March 28, 2008

RE: Harnett County Land Use Application HTE 08-5-19640 Lt 2 Johnsonville Township

An attempt was made to evaluate the above properties for the purpose of issuing an Improvement Permit. The evaluation could not be completed for one or more of the following reasons.

SITE PLAN APPROVAL

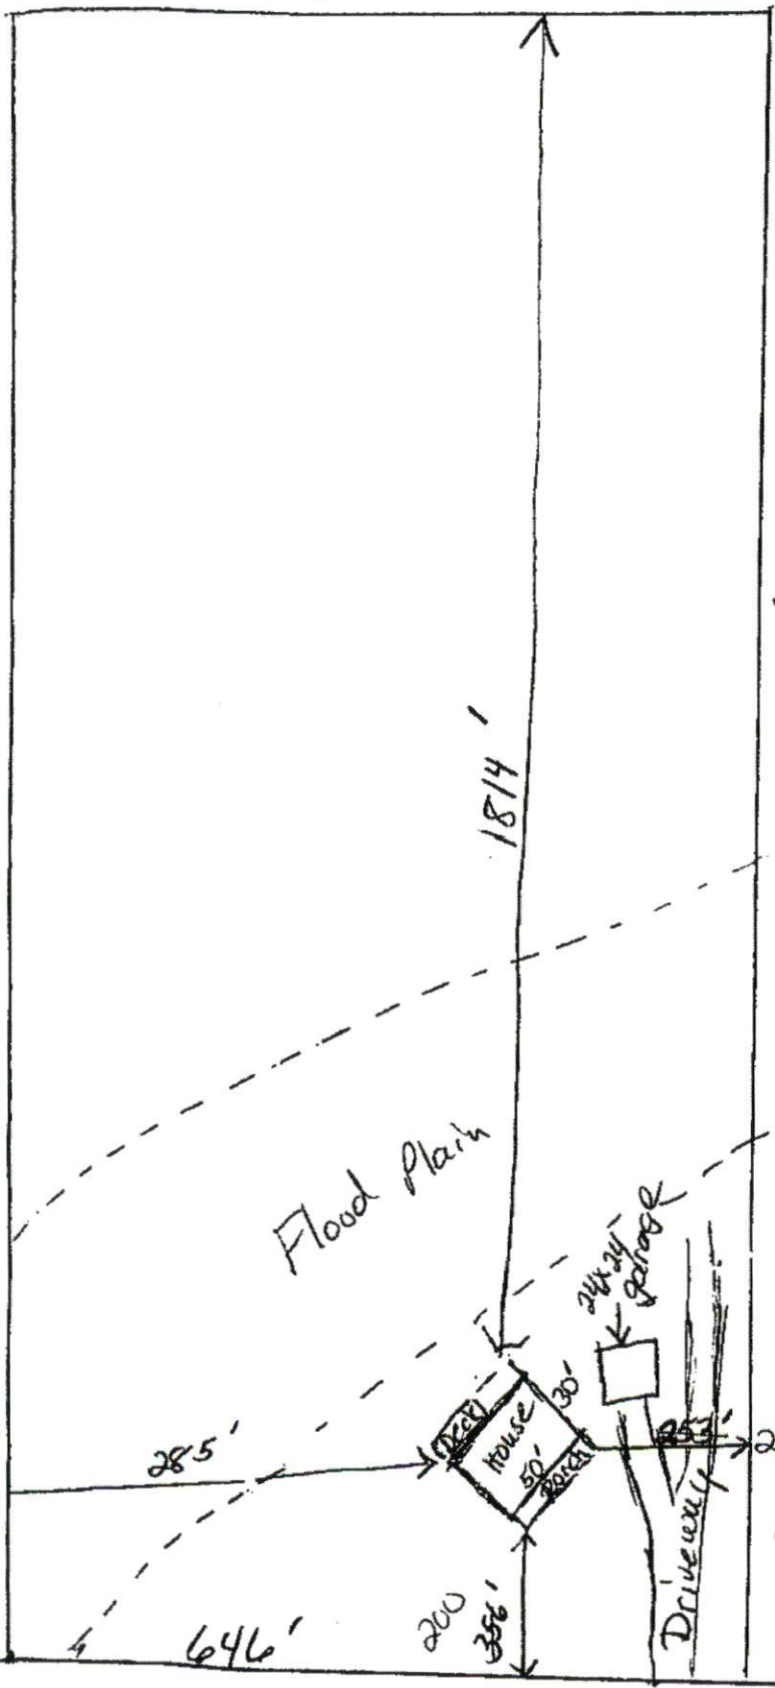
- 1. Property lines (irons)/corners not marked or labeled
- 2. House corners not marked or labeled
- 3. Directions not clear to property
- 4. Property needs brush or vegetation removed
- 5. Backhoe pits required
- 6. Other *In order to accommodate a 5 bedroom home your house site and drive must be moved out of the area shown (see attached sheet). If the number of bedrooms in the home is reduced the home may stay as is, but drive will have to be relocated. You will need to submit a new plot plan with changes to Central Permitting.*

Option #1 - To accommodate a 5 bedroom home, home and driveway and garage must be moved as shown. Note septic system may require the use of a pump

Option 2 - Reduce the number of bedrooms to 3 or 4, leave home as shown on plot plan and relocate driveway and garage as shown. Note septic system may require the use of a pump.
